**Rezoning Transportation Analysis**  
**Petition Number: Insert Zoning Petition #2021-040**  
*General Location Identifier: Tax ID 10505222*

**Revision Log:**

Date	Description
04.29.2021	First Review (WB)
05.27.2021	Second Review (WB)
06.30.2021	Third Review (WB)

CONCEPTUAL SITE PLAN
REZONING PETITION #2021-040
ED HODGES SITE
MATTAMY HOMES
CITY OF CHARLOTTE

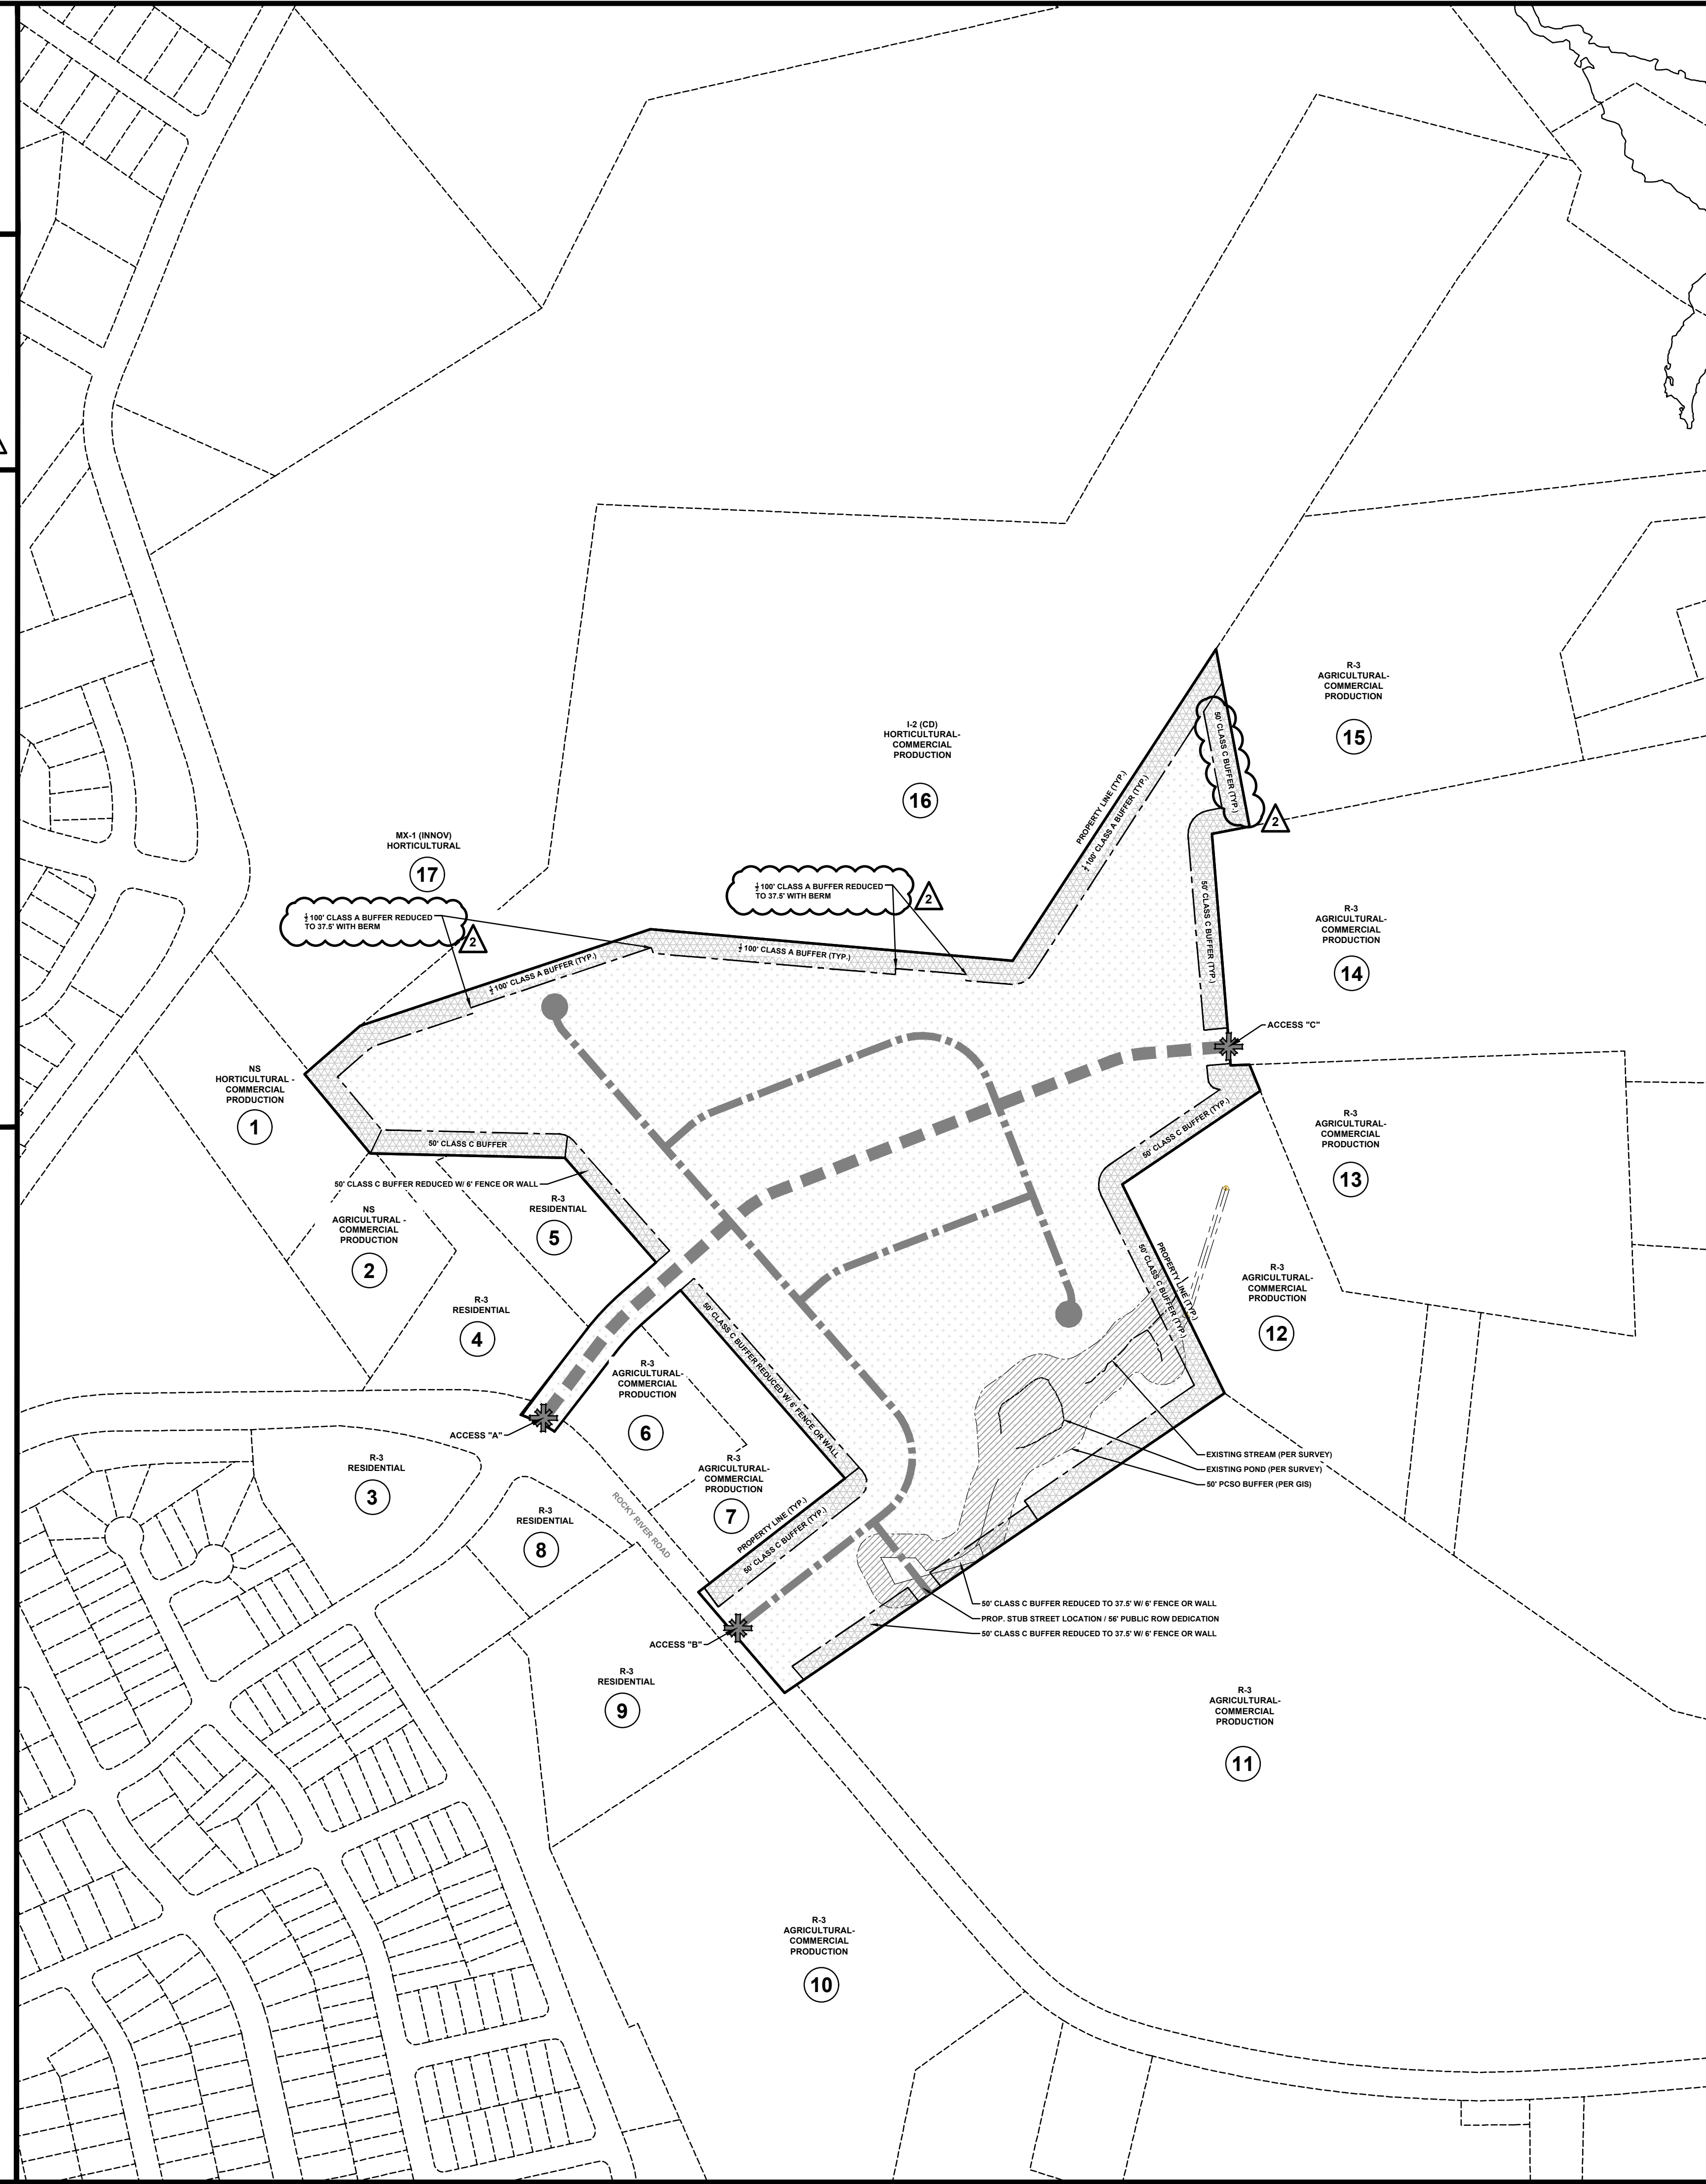
~~a. **Caldwell Road Extension (Recommended on CTP):** 2+ Avenue, Location of curb and gutter is 30' from the road centerline to the back of curb.~~

~~Label and dimension the curb and gutter from the centerline for each road on the site plan.~~

~~3. Revise site plan and conditional note(s) to commit to dedicate 78' right-of-way for the Caldwell Rd Extension (Recommended CTP alignment). The site plan shall label and dimension the right-of-way.~~

~~4. Revise site plan and conditional note(s) to commit to dedicate 50' right-of-way from the Rocky River Road centerline. The site plan shall label and dimension the right-of-way from the road centerline.~~

~~5. Revise site plan and conditional note(s) to commit to construct an 8-foot planting strip, and 6-foot sidewalk on Public Local Roads per Chapter 20. The site plan shall label and dimension both items from the back of curb and gutter.~~

~~6. Revise site plan and conditional note(s) to commit to providing a public street stub to the north per Chapter 20 (Subdivision Ordinance).~~

~~7. Site plan and conditional note(s) revisions are needed to commit to construct bicycle facilities by installing 12' multi-use paths per CLDSM 10.42 on both sides of the Caldwell Rd Extension, and along the site's frontage on Rocky River Road, to meet the City Charlotte BIKE Policy. The site plan shall label and dimension the multi-use paths from the back of curb and gutter.~~

~~8. Site plan and conditional note(s) revisions are needed to commit to realign Rocky River Road to provide a flatter horizontal curve meeting NCDOT Standards.~~

~~9. Revise site plan and conditional note(s) to commit to widen Rocky River Road at Caldwell Rd Extension to provide a left turn lane and a right turn lane into the development per NCDOT standards.~~

- ~~10. Revise site plan and conditional note(s) to commit to restrict the movement at new public street intersection to right turn-in, and right turn-out by installing a median that meets NCDOT standards. The median should not block access to the parcel across the street. The median should extend 50' past the tangent point on both sides of the driveway.~~

- ~~11. Site plan and conditional note(s) revisions are needed to commit to provide a 100' stem measured from the Rocky River Road R/W line per NCDOT Standards. No internal driveways are allowed within this stem.~~

- ~~12. Revise site plan and conditional note(s) to commit to widening Rick River Road to provide a right turn into the development at the new Local Road per NCDOT Standards.~~
